**WEST SUSSEX COUNTY COUNCIL
STRATEGIC PLANNING CONSULTATION**

**SUBJECT: BR-270-17
56 High Street
COU from A1 to A2**

Drawing Site Location Plan and Block Plan

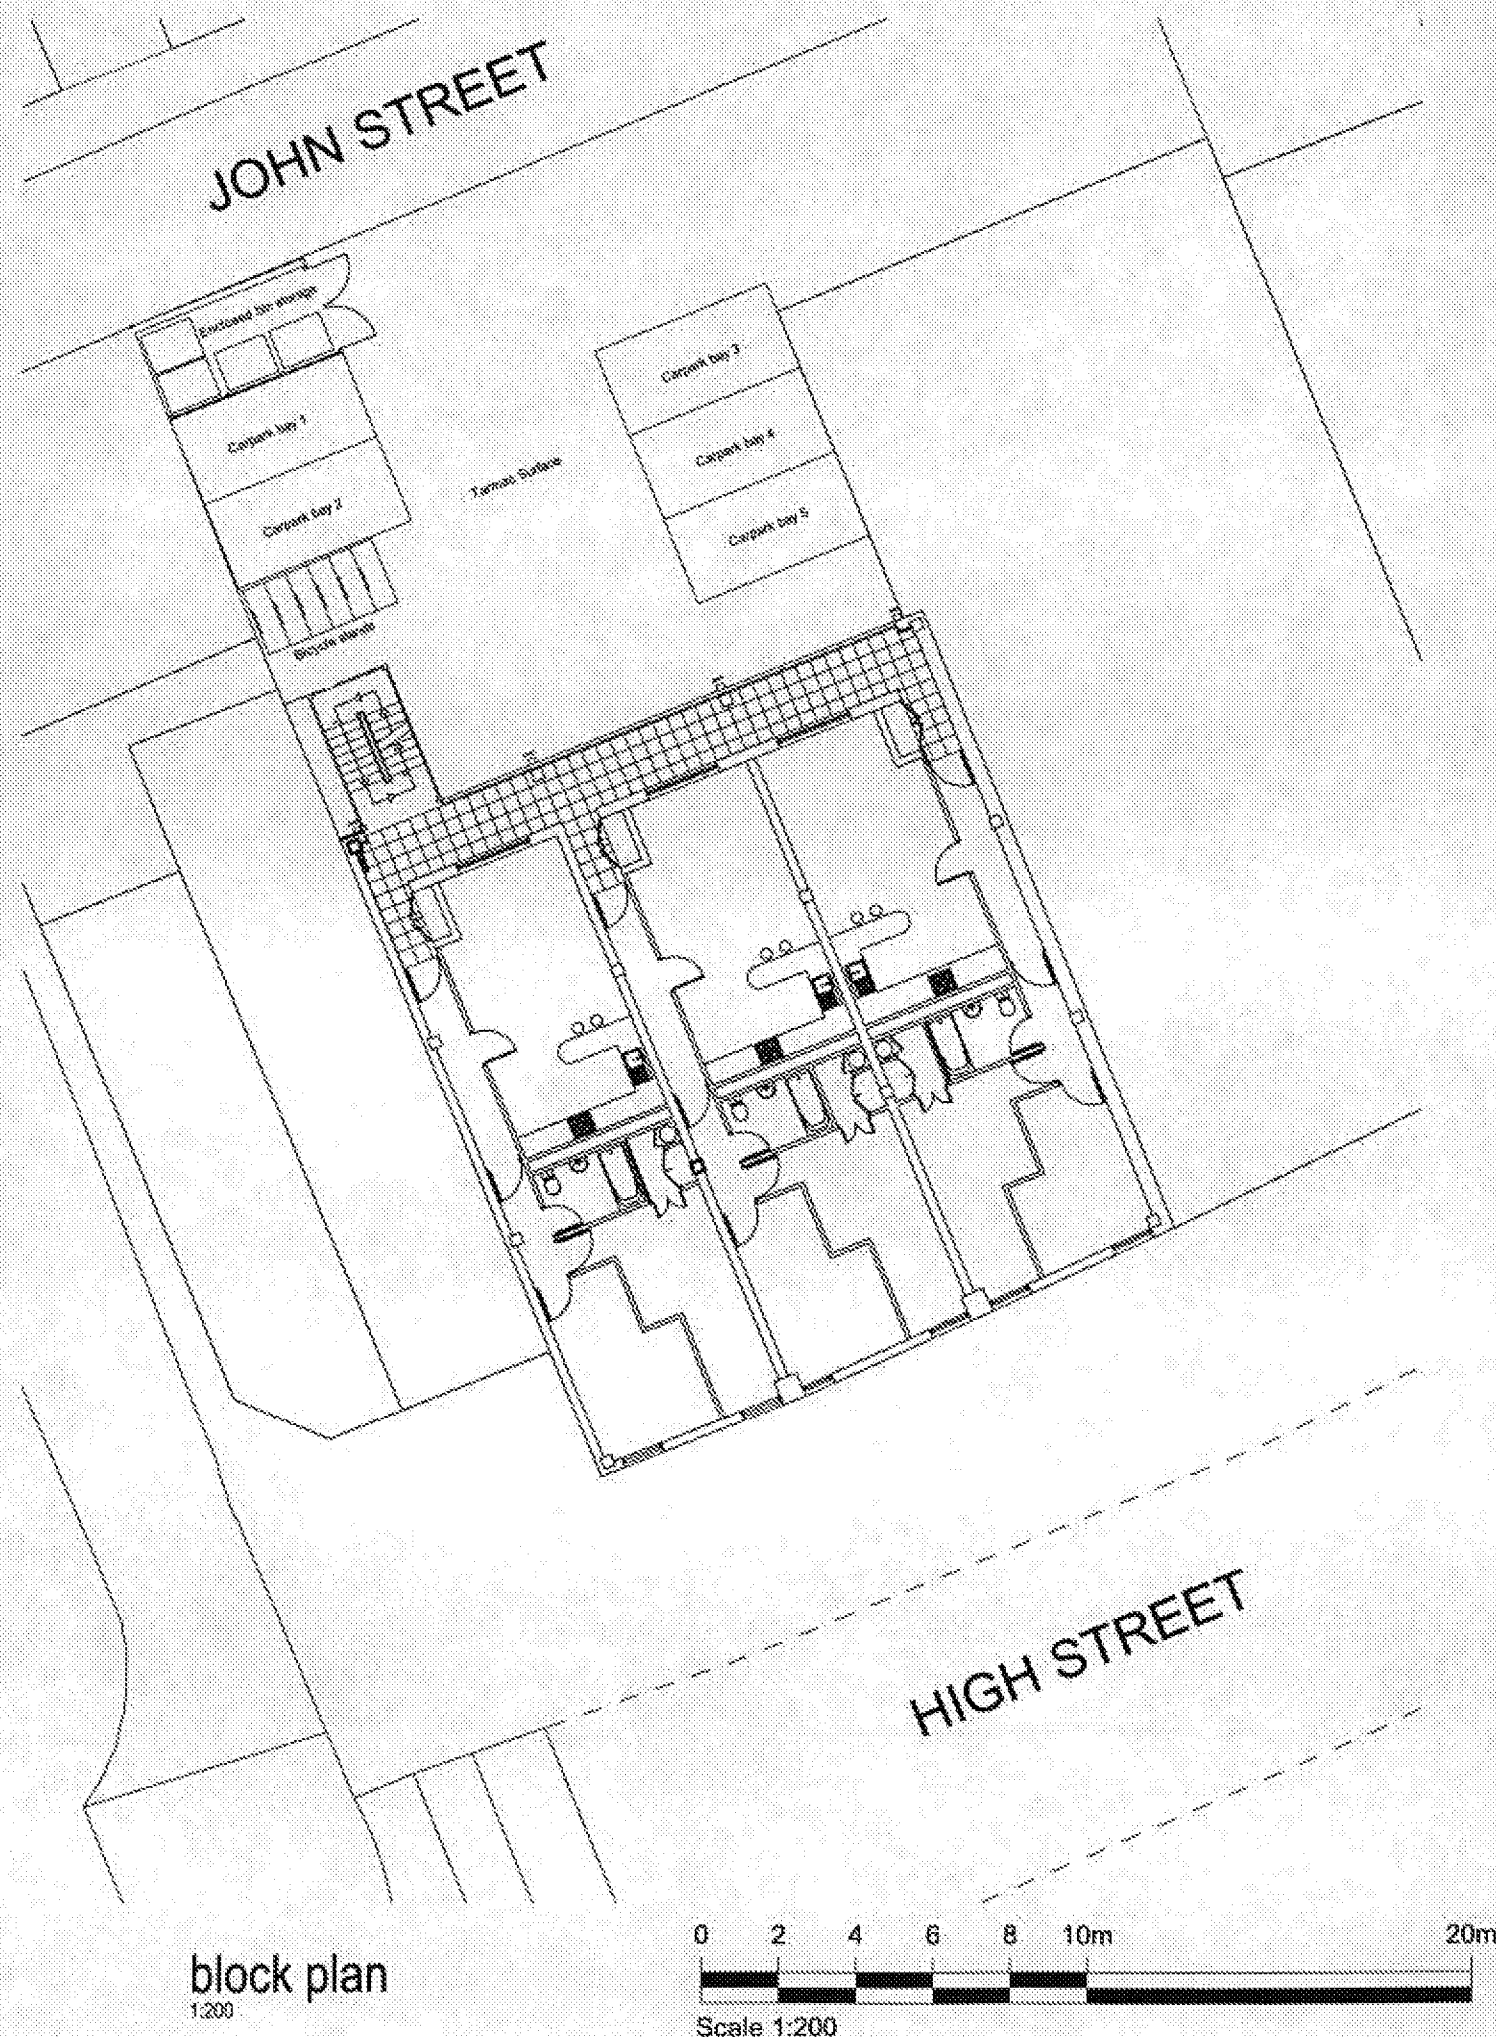
In terms of highway safety and capacity the site will not attract any significant number of cars to the area. There is parking to the rear and the site is within a highly sustainable location directly opposite the main bus stopping area in the High Street, and a 5 minute walk to the station.

There does not appear to be any cycle storage available which would be helpful, if these are to be sold as family residences. During construction should there be a need to use the public highway or footways then a licence will need to be obtained (see informative below)
